Submission by Mallard Pass Action Group (MPAG)

**Comments on Rule 17 letter
ExA request for further information - BMV**

Comments on Rule 17 letter from the Planning Inspectorate – Request for further information

Q2) Land Use & Soils

**Table 12-1: ALC Results for the Order limits and Solar PV Site Area**

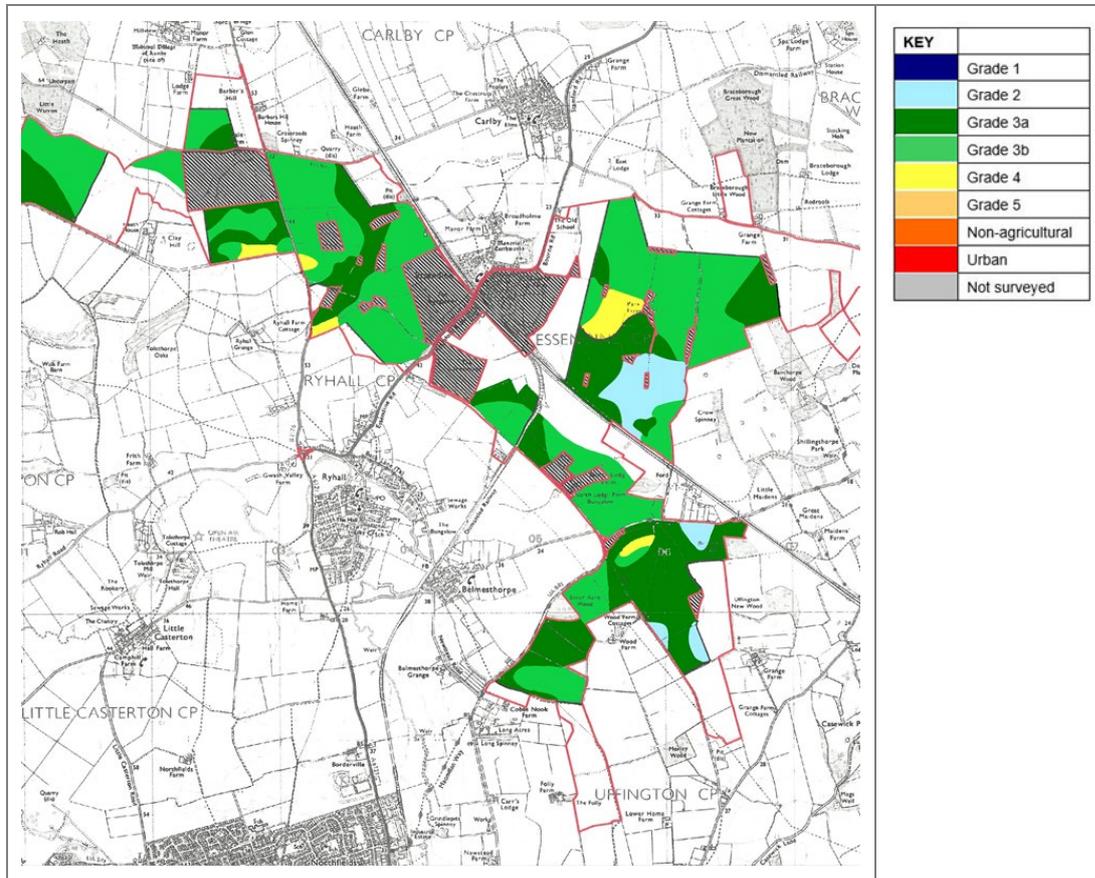
1. The area for biodiversity and arable should be split into its constituent parts, as the ‘biodiversity only’ area will be taken out of food production, therefore lost on a temporary basis for 60 years.
